15 December 2021

File No: 2021/555102
Our Ref: R/2016/37/D, R/2020/13/B, R/2016/36/E, R/2016/35/E
Your Ref: SSD 6964 MOD 5, SSD 6965 MOD 4, SSD 6966 MOD 2, SSD 8892218 MOD 2

SSD 6964 MOD 5, SSD 6965 MOD 4, SSD 6966 MOD 2 & SSD 8892218 MOD 2 – Barangaroo South – Building R4A, Building R4B & Building R5 – Basement Layout Amendments – Advice on Modifications

Figure 3 | Proposed plan of Level B1, with clouded pink/blue spaces reallocated to Building R4B, and clouded white spaces reallocated to Building R5

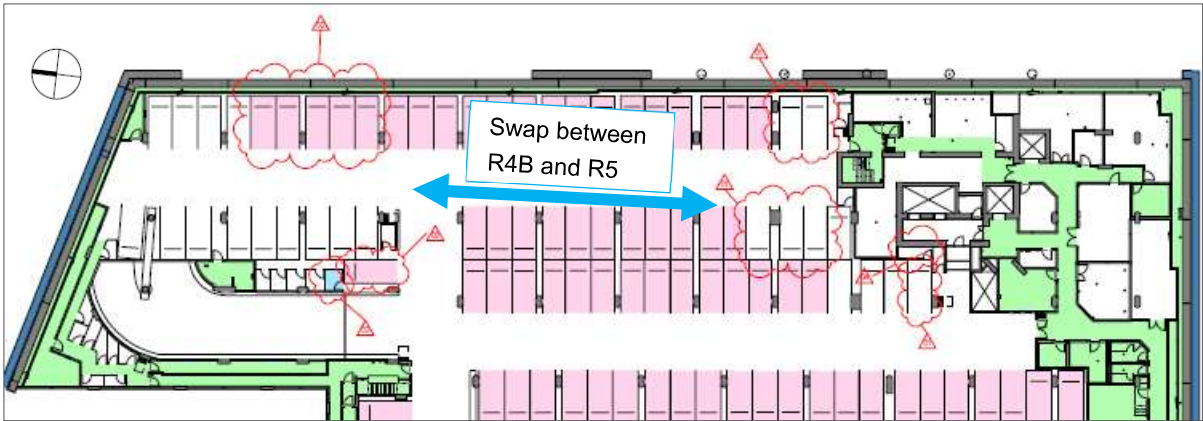
- Level B1: Reallocation of six parking spaces and associated storage cages from Building R4B to Building R5.
- Level B2: Reallocation of five car parking spaces and associated storage cages between Building R4A and Building R5.
- Level B2: Removal of two storage cages and addition of one storage cage within a garage at the rear allocation to Building R4A.
- Level B3: Reallocation of three car parking spaces and associated storage cages between Building R4A and Building R5.

Overall, the proposed reallocation of car parking spaces and storage cages relate to a locational swap only, do not involve any physical changes and will not impact the total approved car parking spaces for each building. Further, the removal of the storage cages is noted to improve vehicle access while still achieving the ADG minimum storage space required to be provided to the allocated apartment.

The City does not raise any objection to the proposal, subject to compliance with existing approved car parking maximums and achieving ADG storage minimums.
